September 9, 2022

Subject: *2nd Review Completion Letter*
 Koneru Short Plat, File No. SUB21-008
 PACE Project No. 21436

C1.0
SHEET

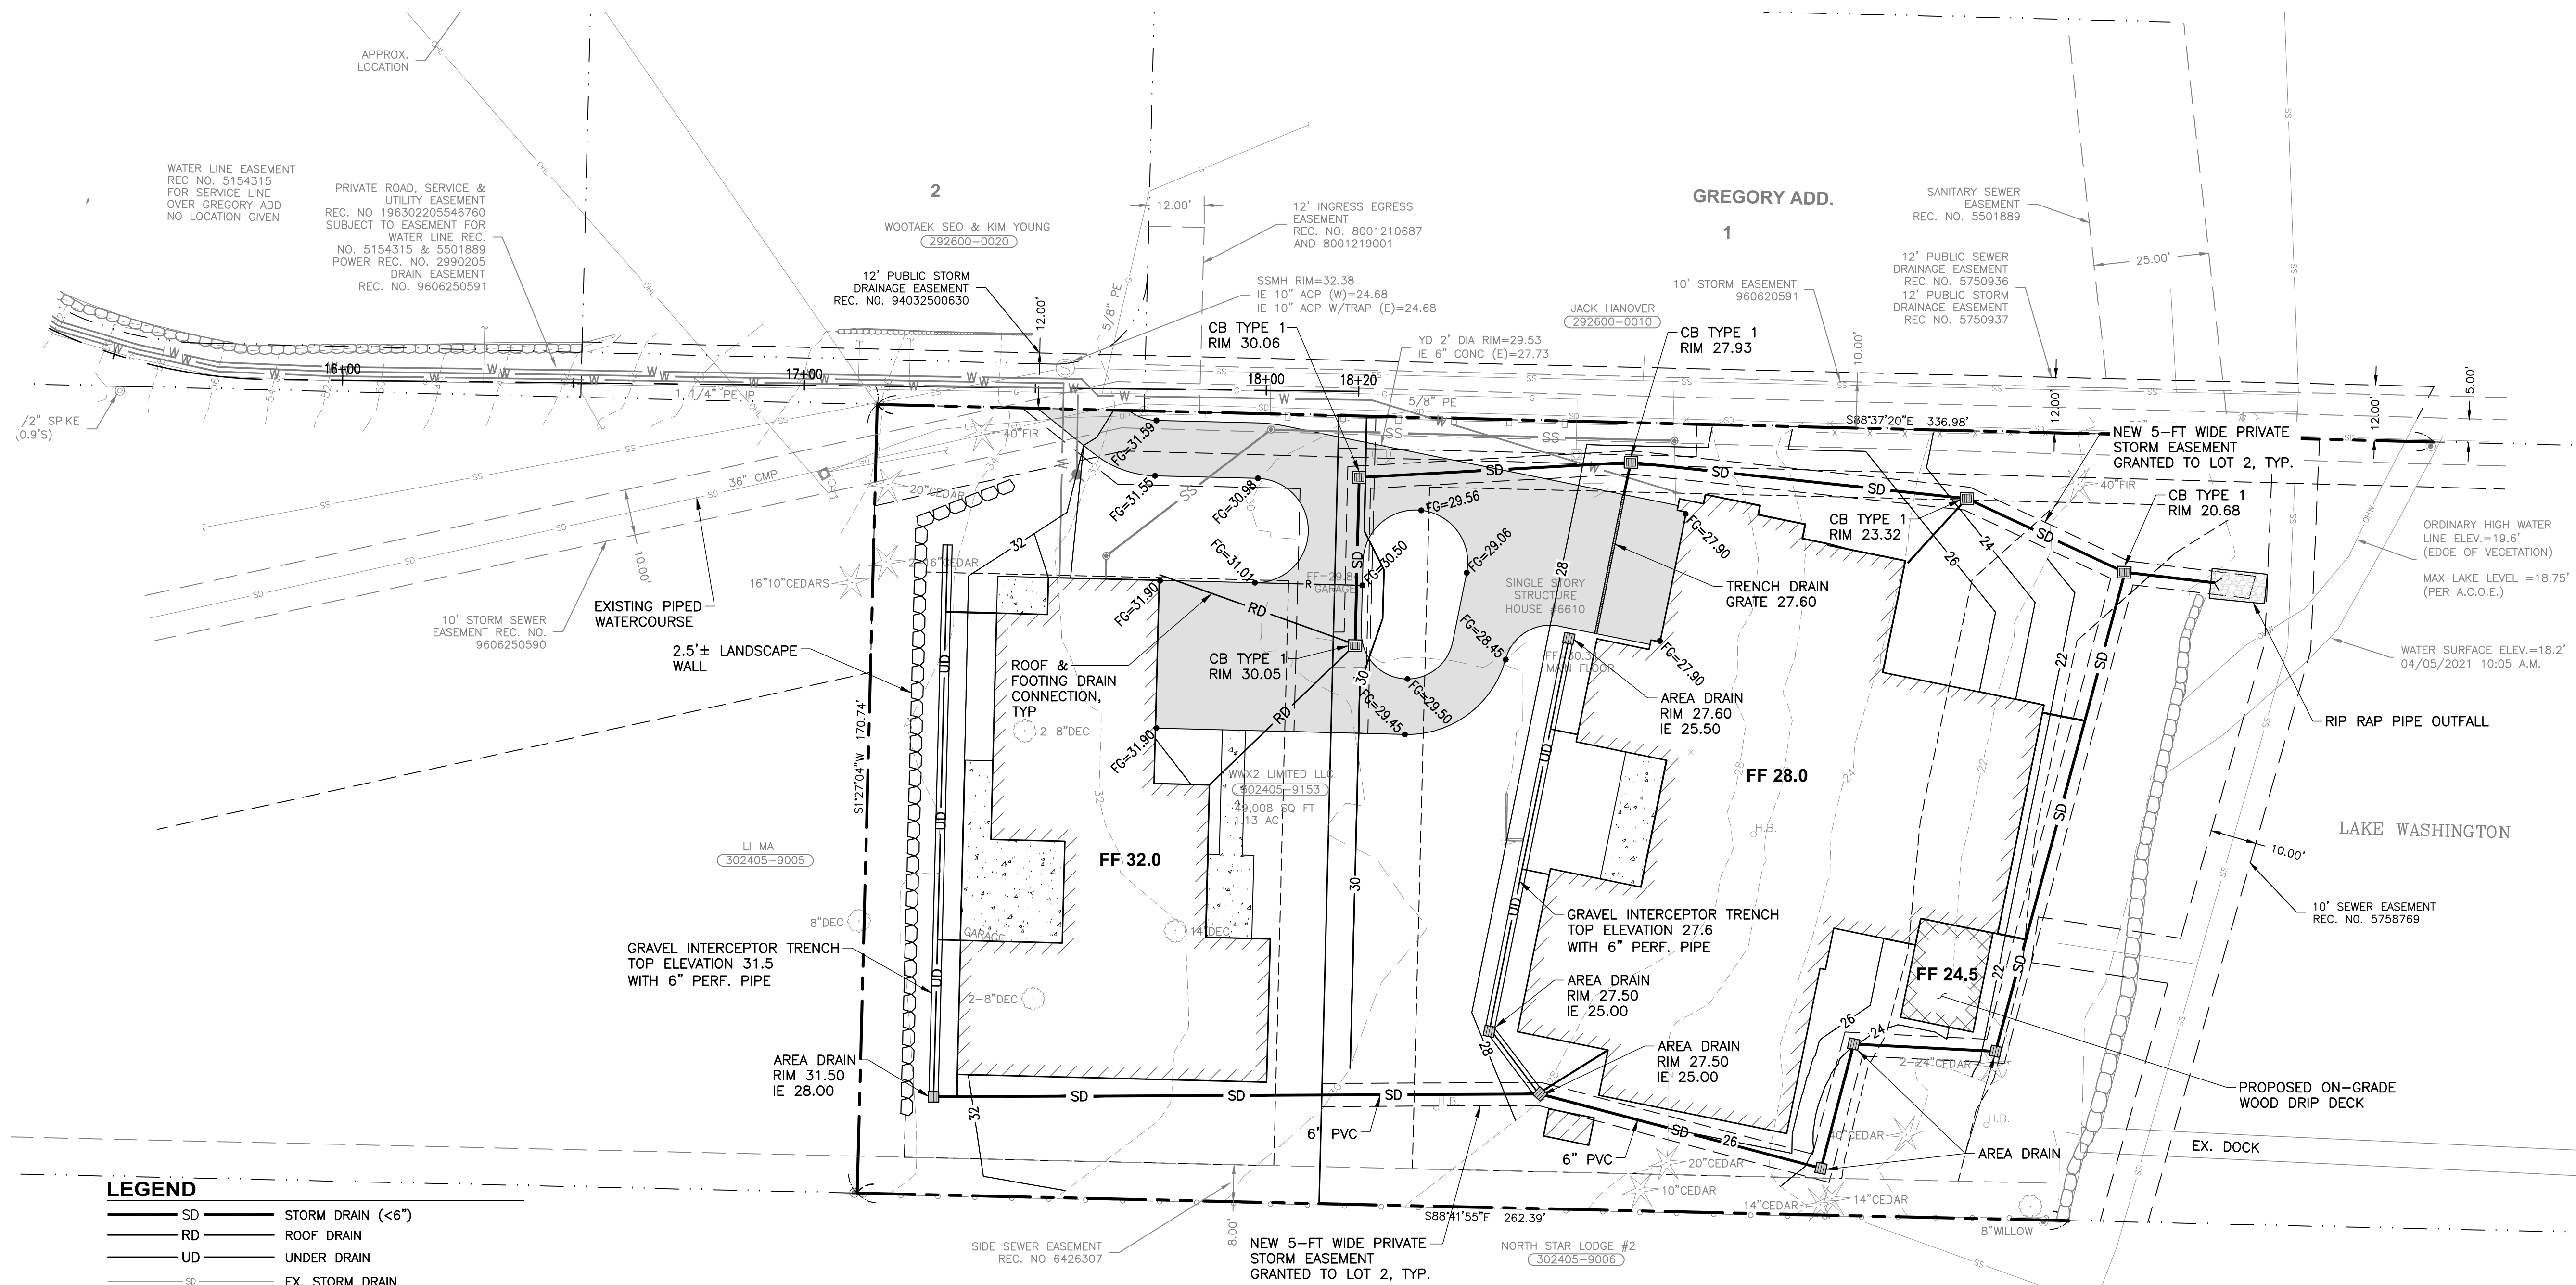
2. Clarify whether the easements that the road/service/utility easement is subject to are private or public.
PACE Response: As noted in the callout, all easements are private easements between landowners.

3. For all easements shown, clarify if it is a public or private easement.
PACE Response: "Public" has been added to the appropriate easement callouts.
4. Clarify if this new private storm easement is for the benefit of Lot 2.
PACE Response: The private storm easement across Lot 1 is for the benefit of Lot 2.

5. Please either use different line types/weights to clearly distinguish the easement lines from the setback lines or use a separate easement plan from the setback plan. It is difficult to distinguish lines.
PACE Response: Linetypes have been updated to better clarify easements from setback lines. Additionally, more labels have been included to clear up any confusion.

6. Clarify if easements are existing or proposed.
PACE Response: All easements not located on the subject parcel are existing.
7. What is this 7-ft dimension representing?
PACE Response: This 7-ft dimension represents the private side sewer easement granted by Lot 1 to Lot 2.

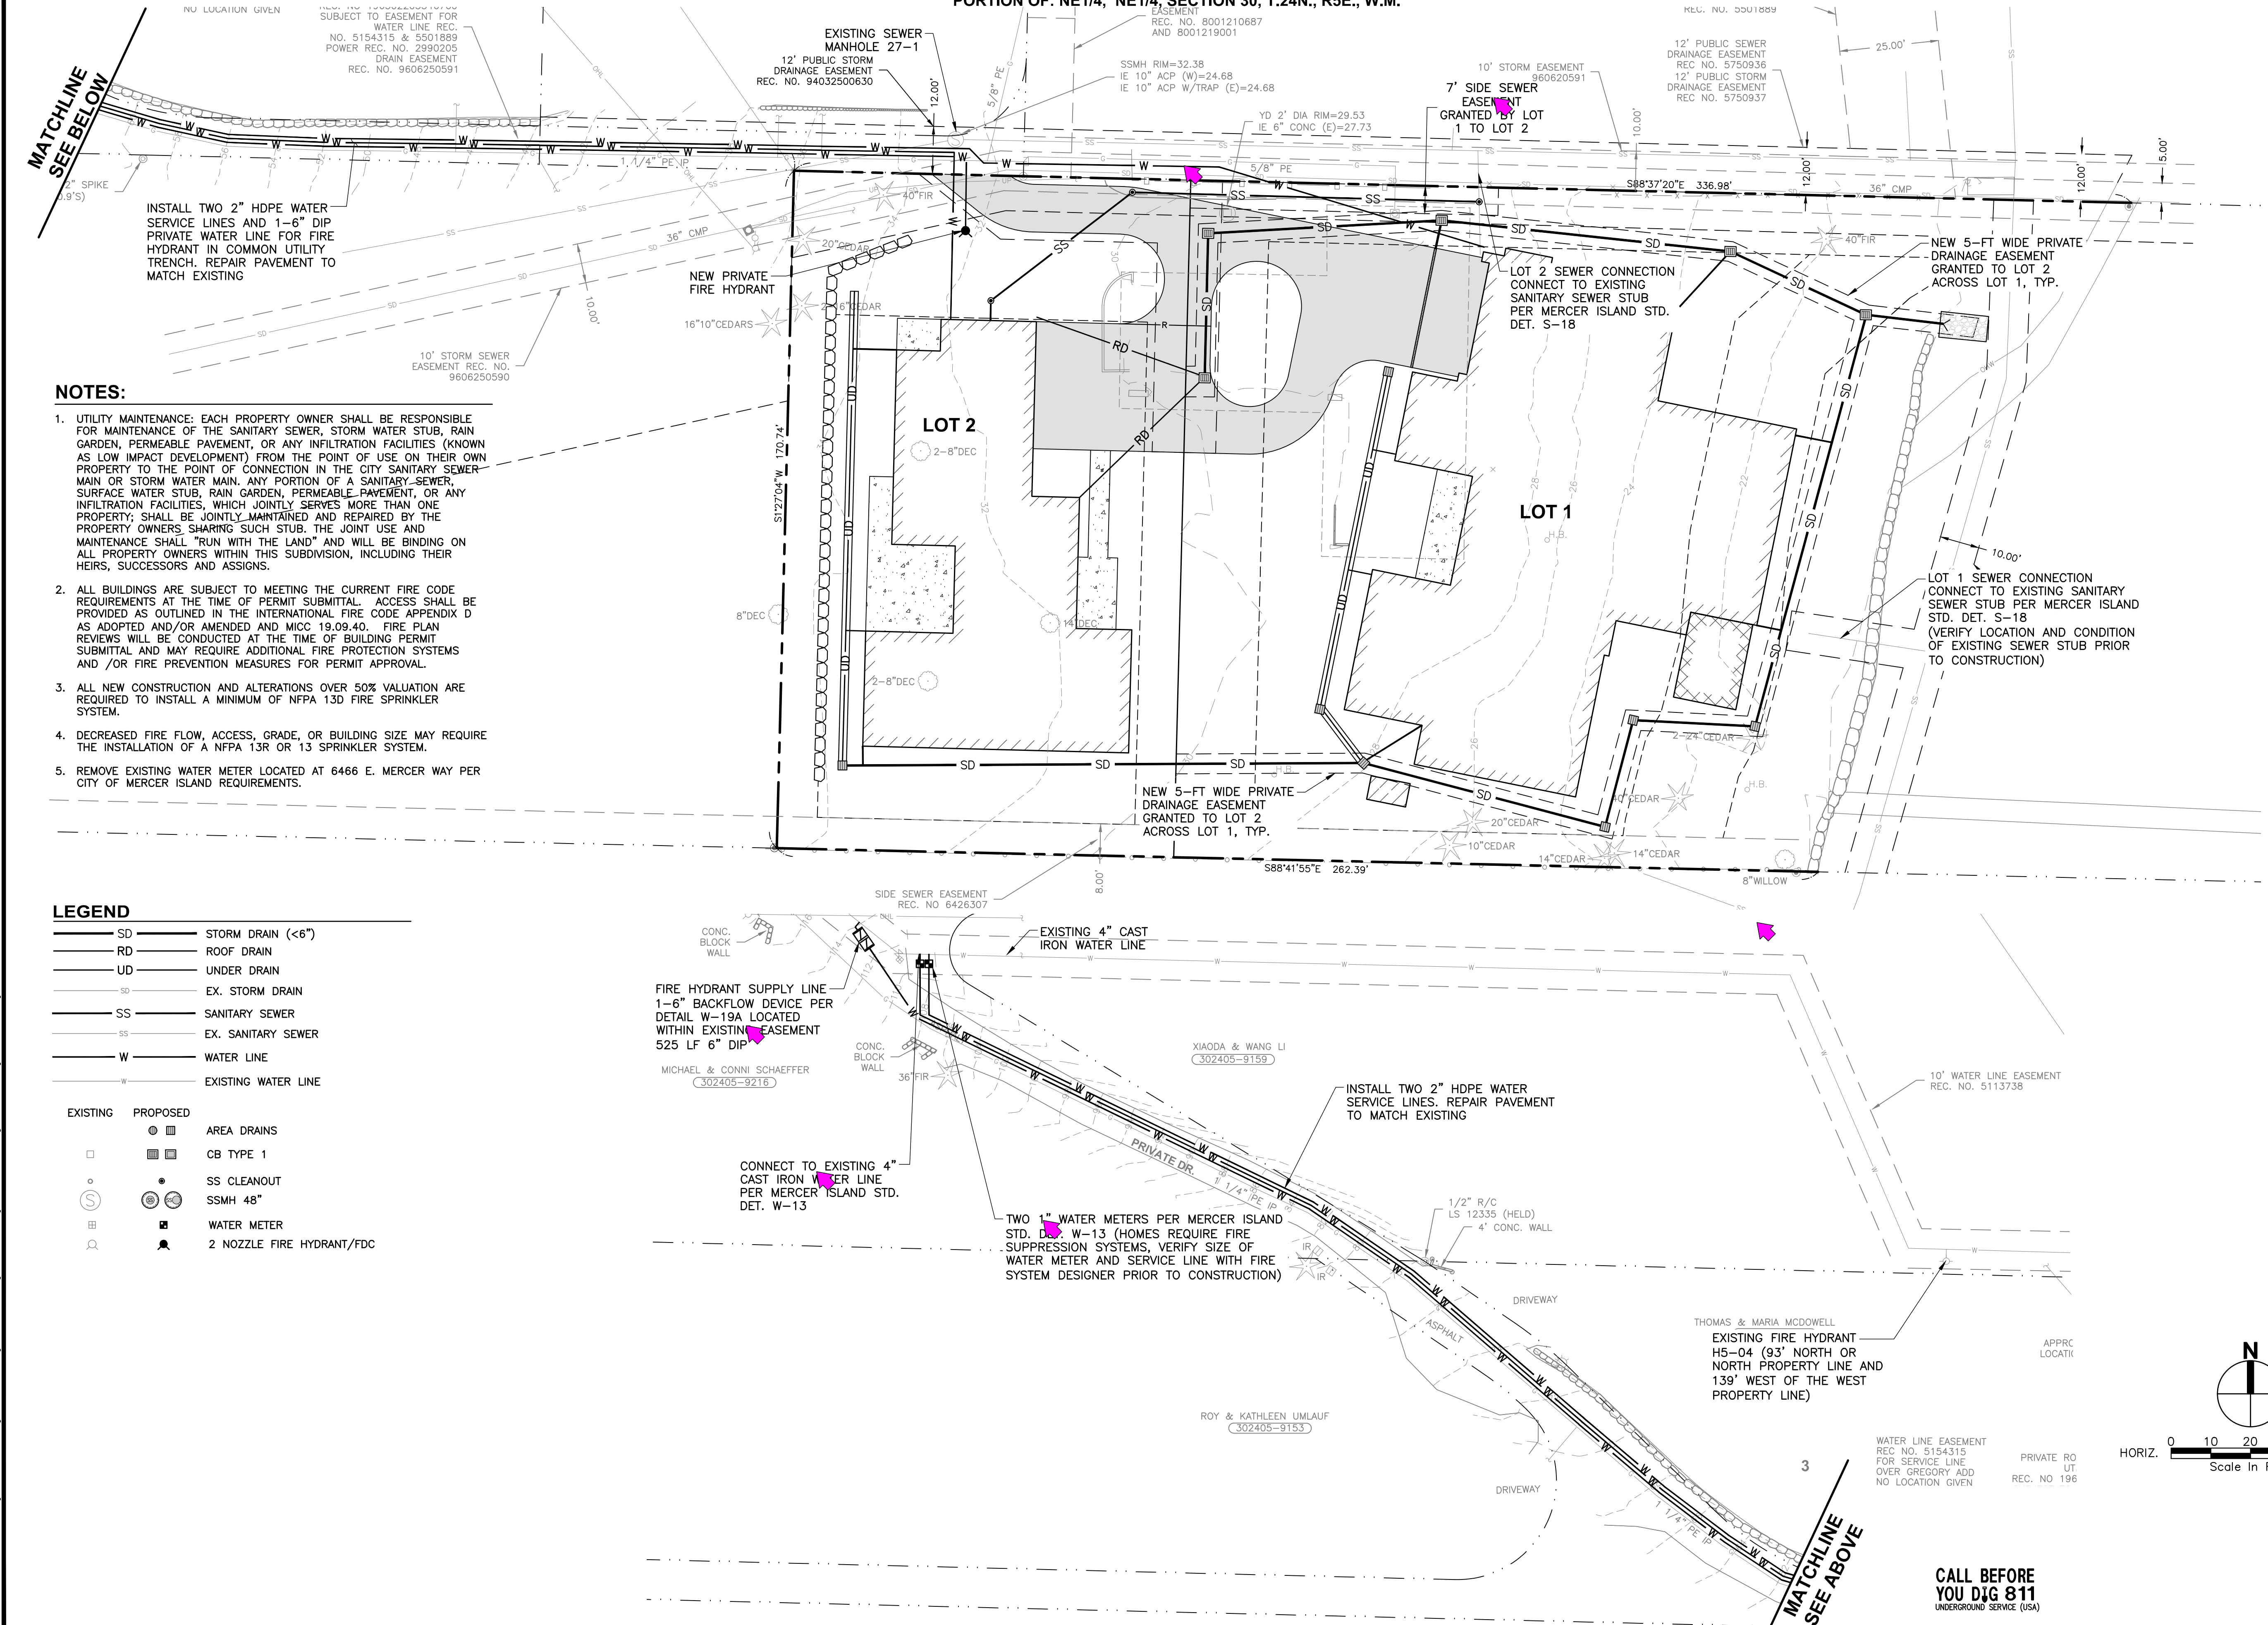
9. The private side sewer easement and private sewer line cannot be inside the public drainage easement.

10. The private water line cannot be inside the public drainage easement.

11. Please note that the new water service line must be connected to the 6-inch water main, not the 4-inch water main.

PACE Response: Private side sewer and sewer line have been updated to be outside the public storm drainage easement to the max extent feasible. Given the location of the existing sewer stub for the parcel and location of existing utilities along the north property line, the least impactful location for the side sewer is as shown on the plans.

PACE Response: The private water line has been updated to be outside the public drainage easement.

PACE Response: The new water service line has been updated to connect to the existing 6-inch water main.

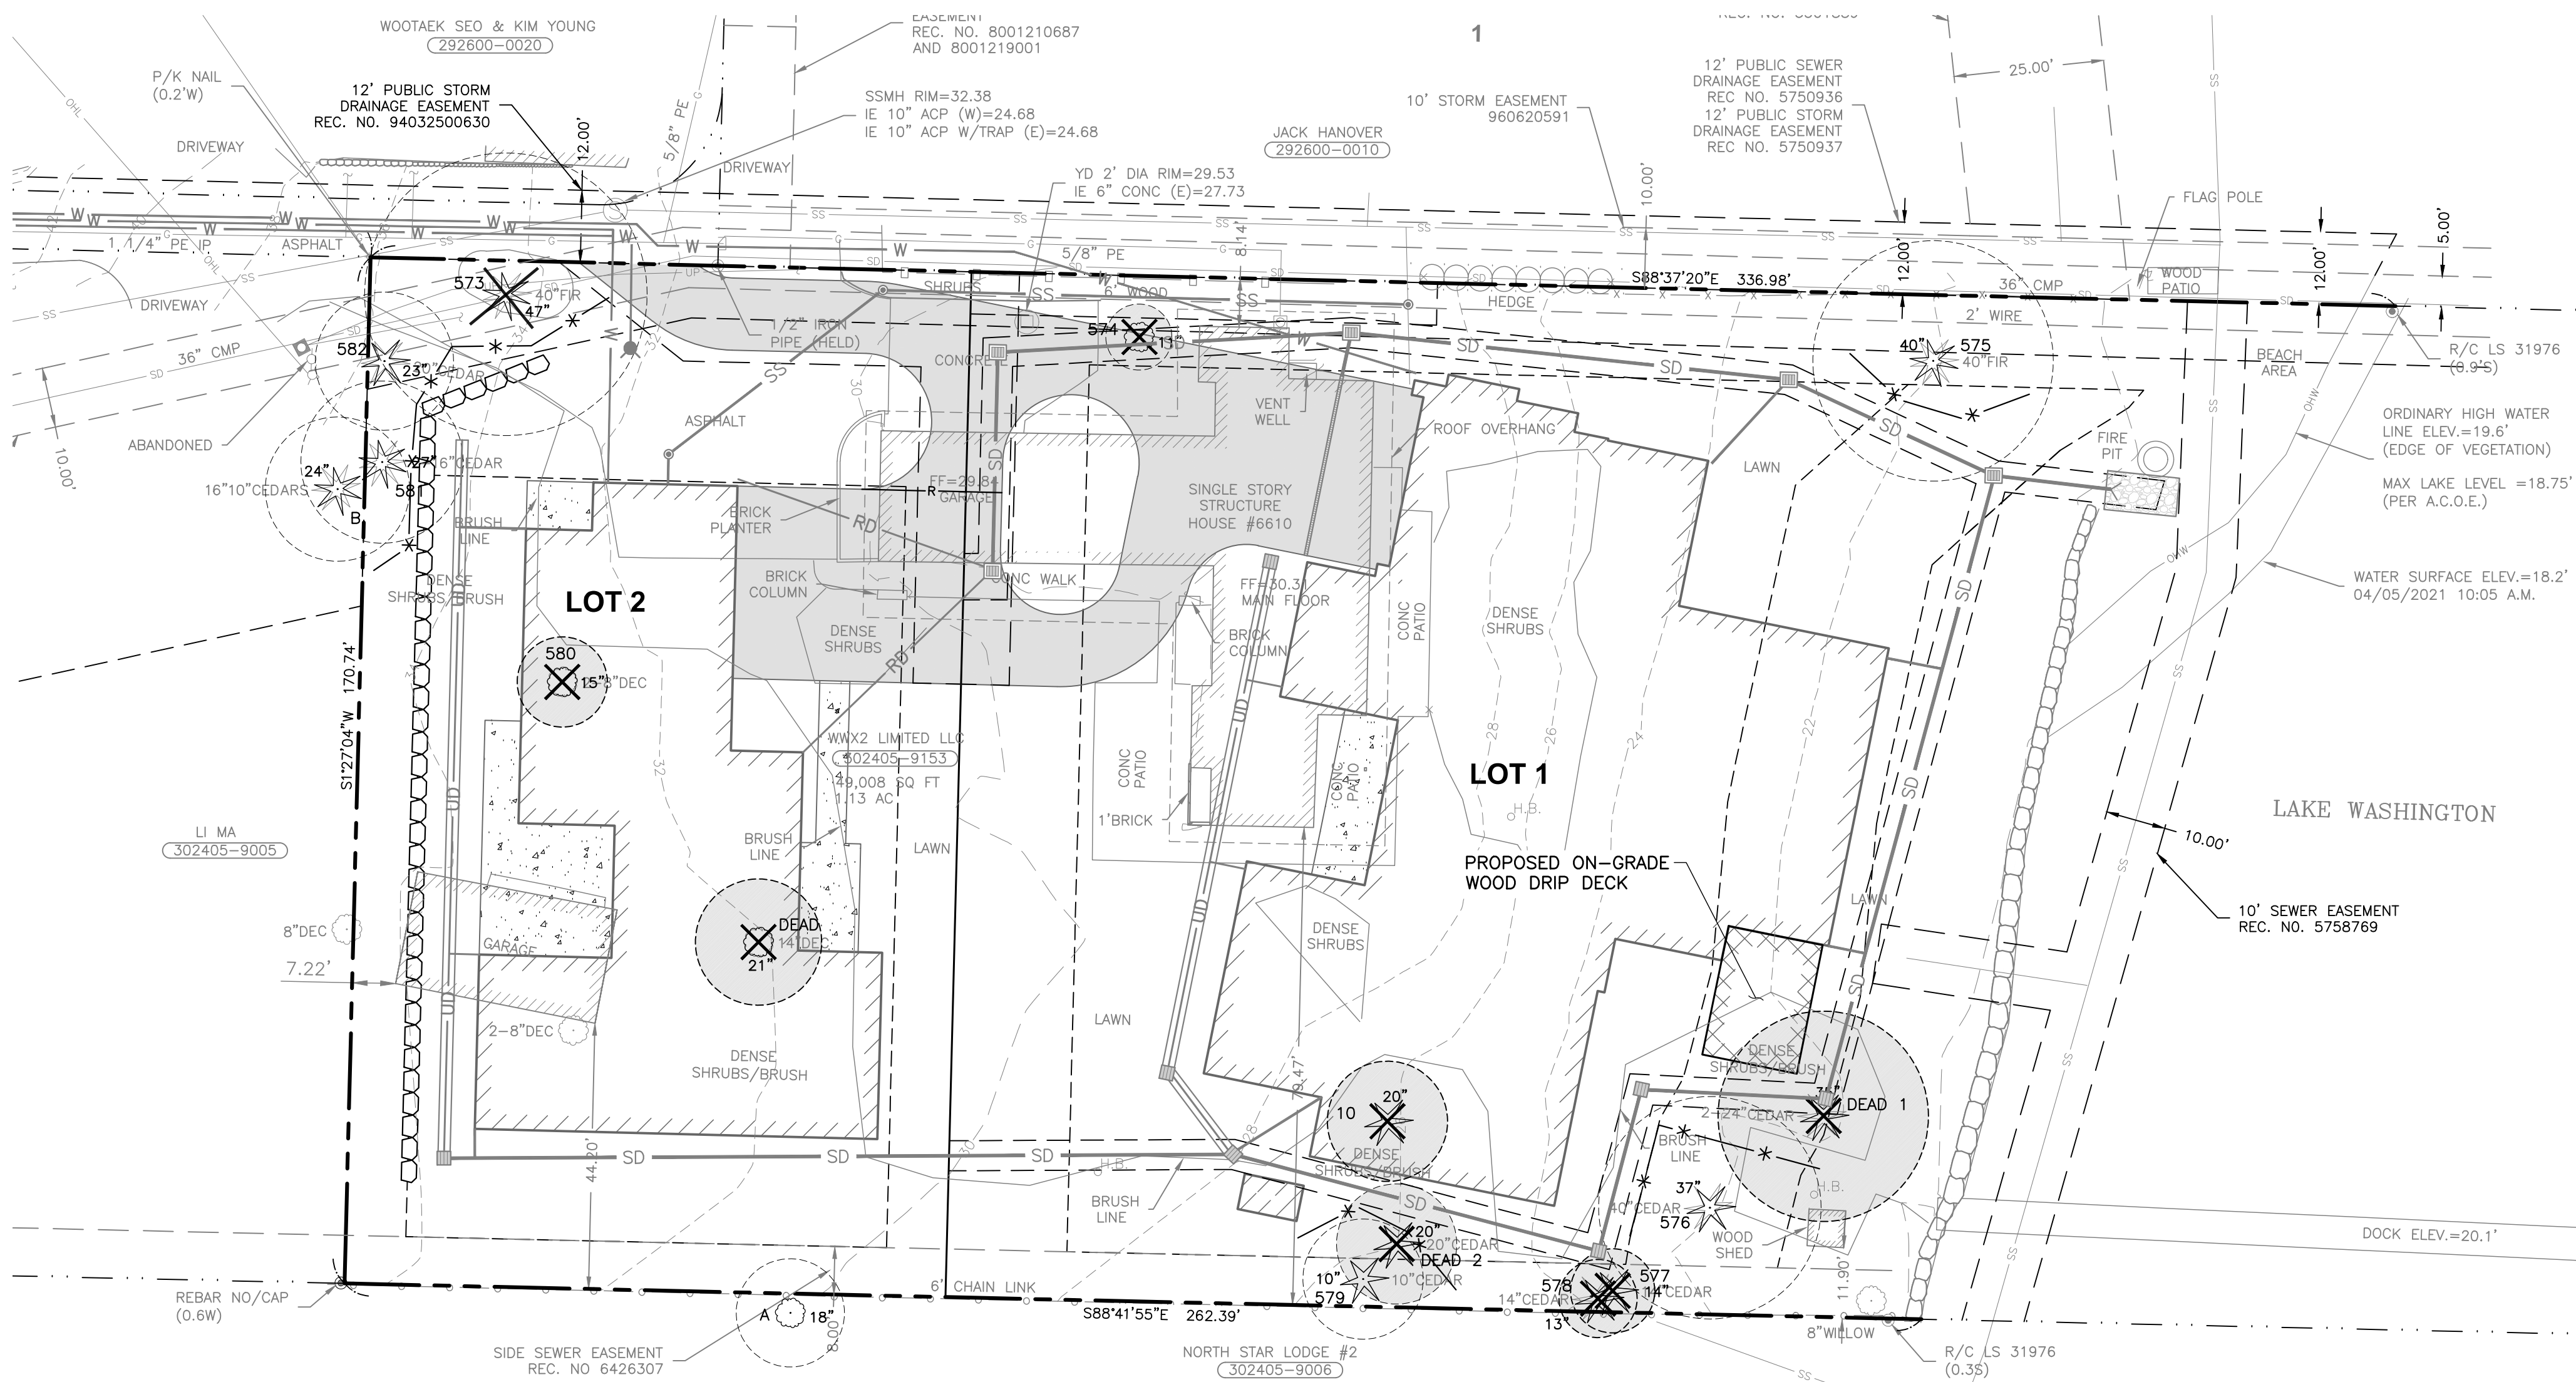
4. Tree 573 is exceptional in size and now shown for removal. Fire had approved SUB 1; what has changed? The new hydrant is beyond the minimum recommended limits of disturbance. Please provide the access and hydrant requirements that conflict with the tree. Could some asphalt removal mitigate for the impacts of the new improvements?
PACE Response: Tree 573 has been shown as removed because of the extent of utility installation.

7. Protect Tree 580 that is shown for removal but not on the proposed lot for development. It appears the plan from the subdivision was used. A specific tree protection plan for building is required, see comment 2.

PACE Response: The single-family permit is for one parcel, not the two-lot short plat. Tree 580 is on the existing subject parcel for this building permit; therefore, removal of the existing tree is allowed.
